**RE: PRE-94-24 Land to the rear of Meadow Way, Westergate – Highways Comments**

Thank you for your pre-application response dated 22<sup>nd</sup> November 2024, please find enclosed our response to the items raised.

- Additional paving and crossing points, enhancing the pedestrian safety when navigating the site.

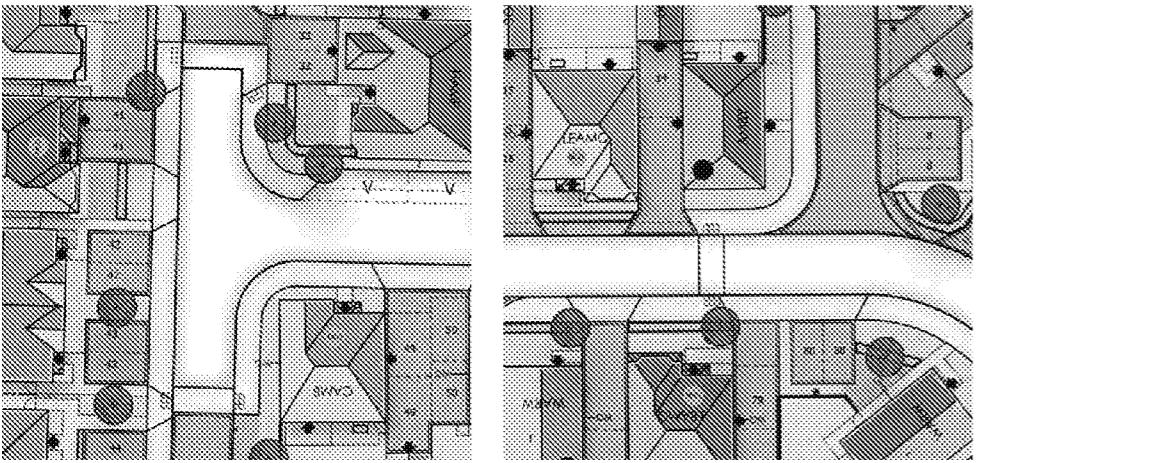
- Regarding the spine road we have now added a traffic calming zone as shown below to reduce vehicle speeds and enhance pedestrian accessibility.

- Footways now terminate onto the shared surface directly to avoid ambiguity.
- The internal links to the PROW have now been removed due to objections by residents.
- The cycle / footway route from Hook Lane is a consistent 3m.
